# **OXFORDSHIRE COUNTY COUNCIL'S RESPONSE TO CONSULTATION ON THE FOLLOWING DEVELOPMENT PROPOSAL**

**Application no:** 15/01012/OUT-3

**Proposal:** OUTLINE - Development of up to 48,308sqm of employment floorspace (Class B1c, B2, B8 and ancillary B1a uses), the siting of buildings to the south of the site, servicing and circulation areas, vehicular and pedestrian access from Skimmingdish Lane and landscaping

**Location:** Skimmingdish Lane, Bicester

Drawing 3830-28-09 - January 2016

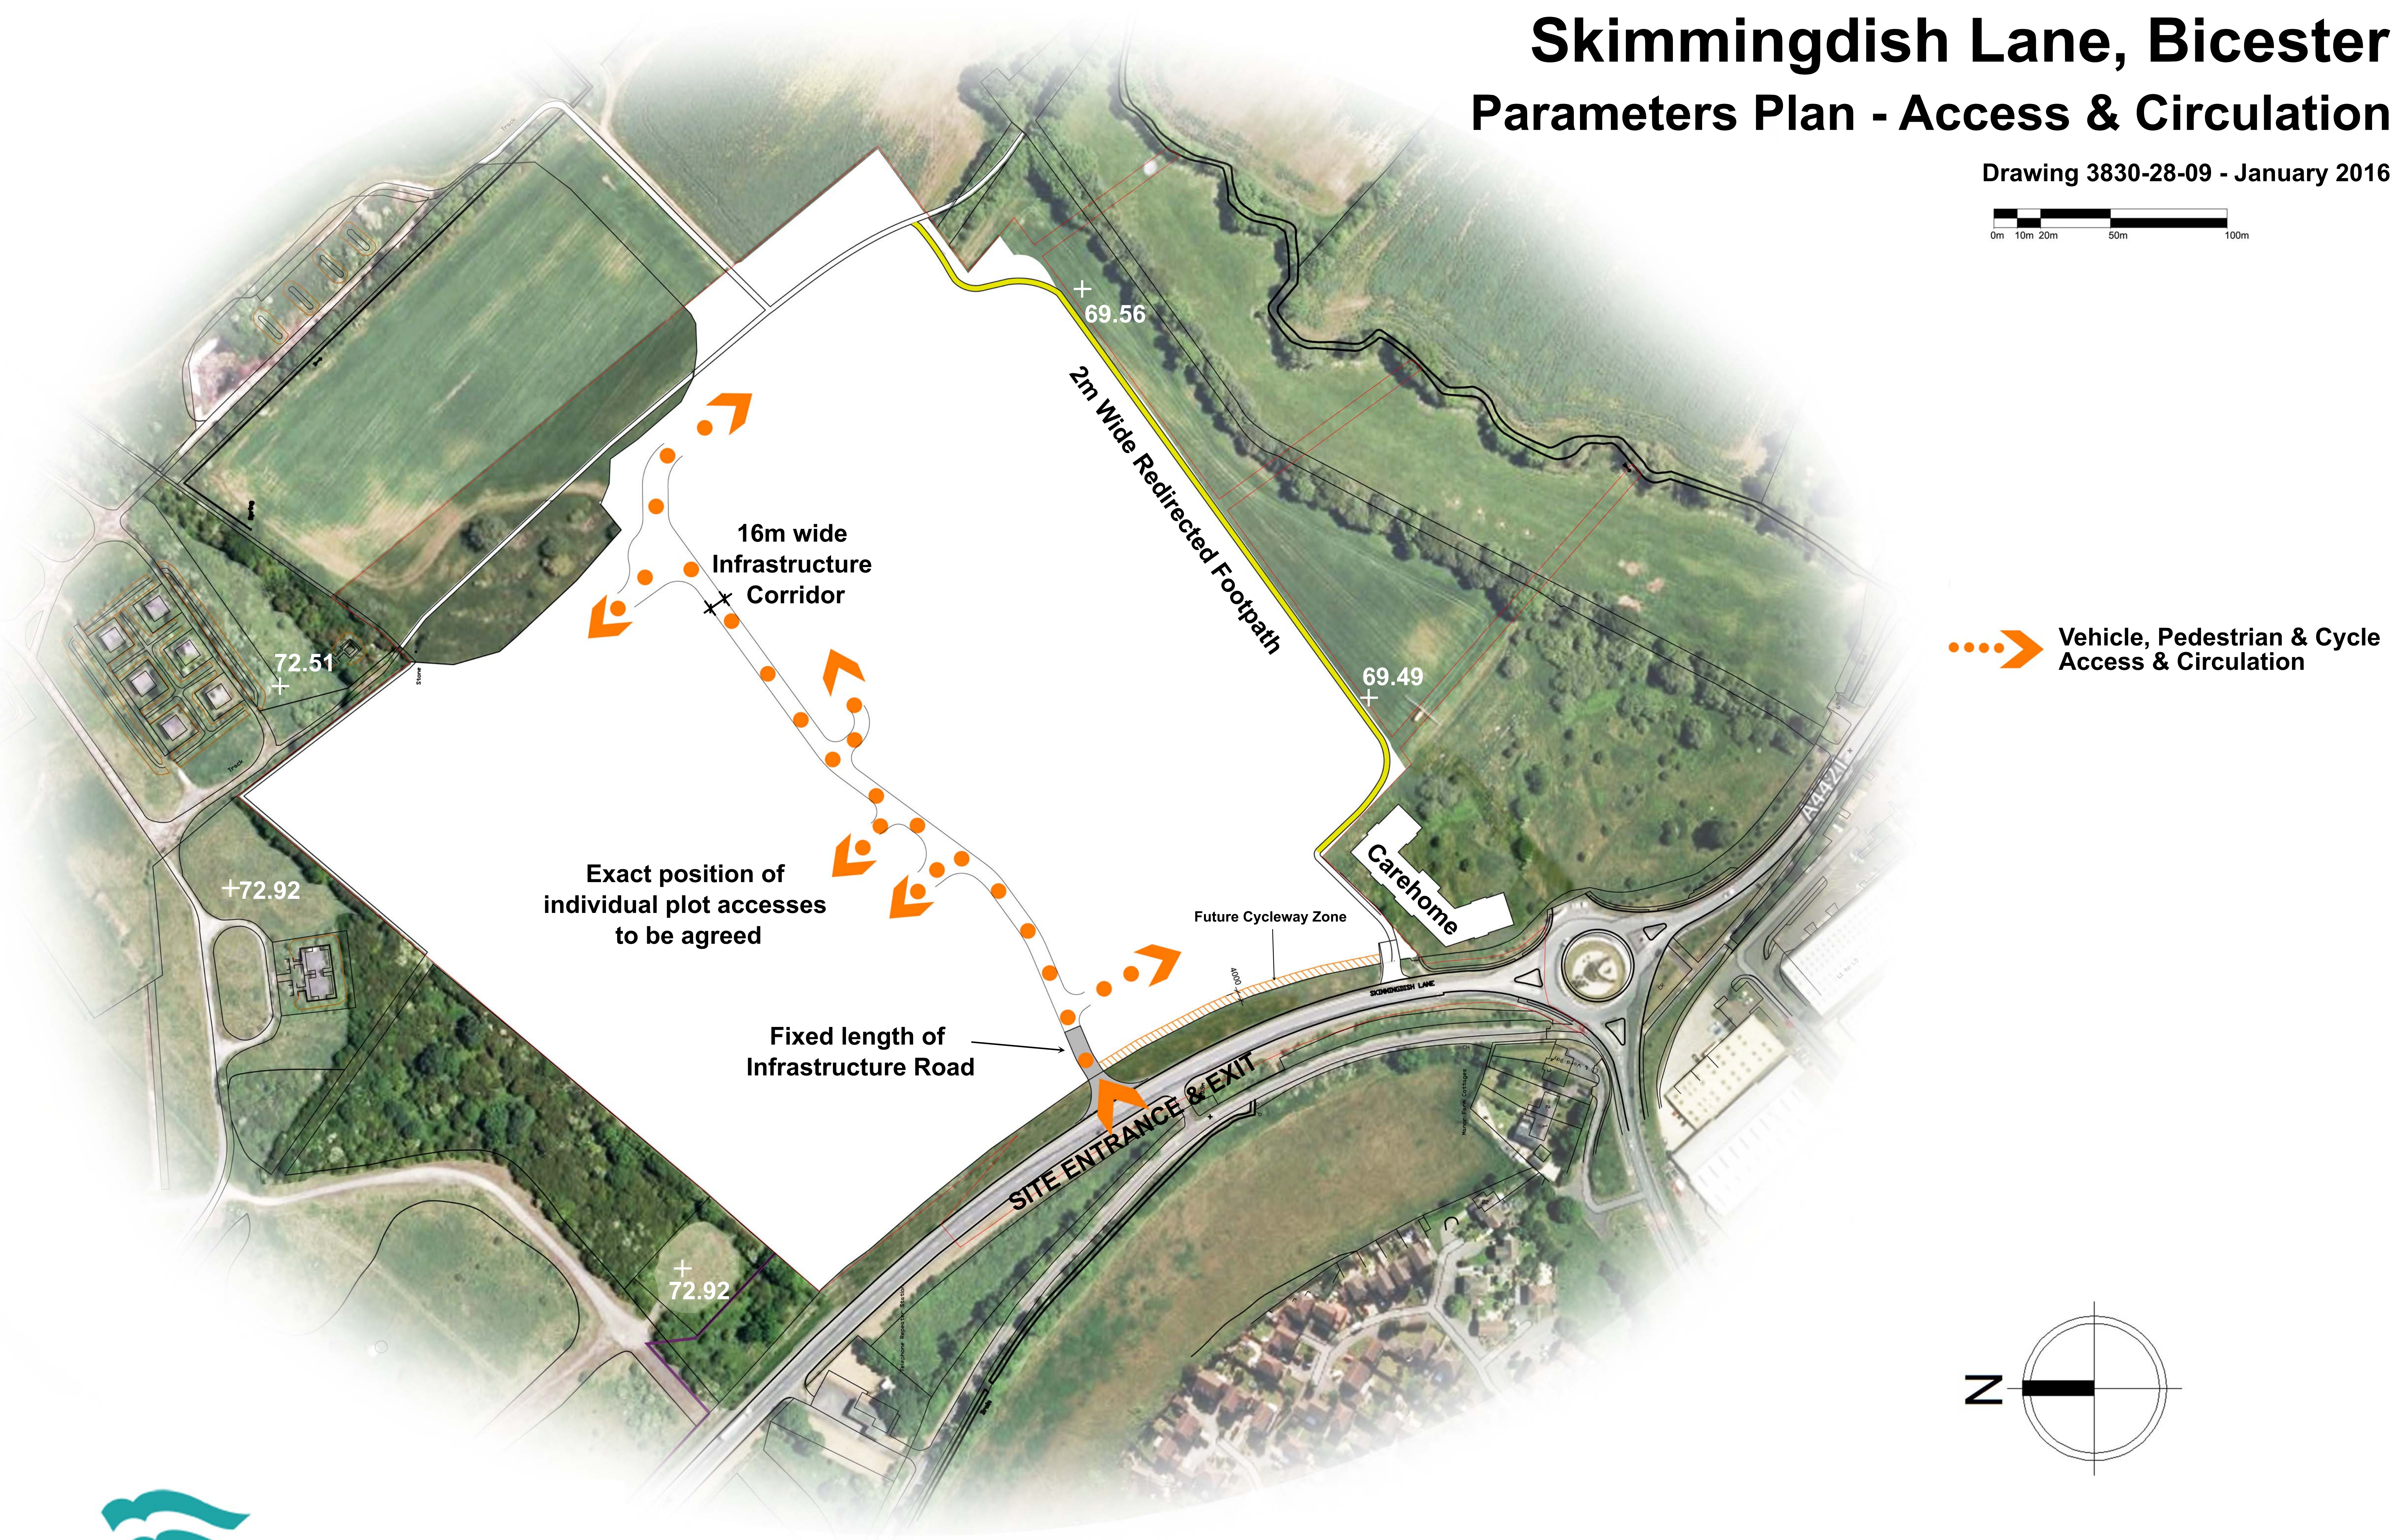
The amendments include a proposed list of conditions and obligations, and a parameter plan (3830-28-09) showing a 4m-wide 'Footway Cycle' zone between the main site access and the public footpath access onto Skimmingdish Lane at the southeastern corner of the site.

- The proposed footpath diversion is acceptable.
- The footway-cycleway zone proposed is welcomed but it is assumed to be in addition to the previously agreed access arrangements, which include a new footway/cycleway adjacent to the carriageway. The purpose of the zone is to ensure that pedestrian and cycle access can be provided following future dualling of Skimmingdish Lane.
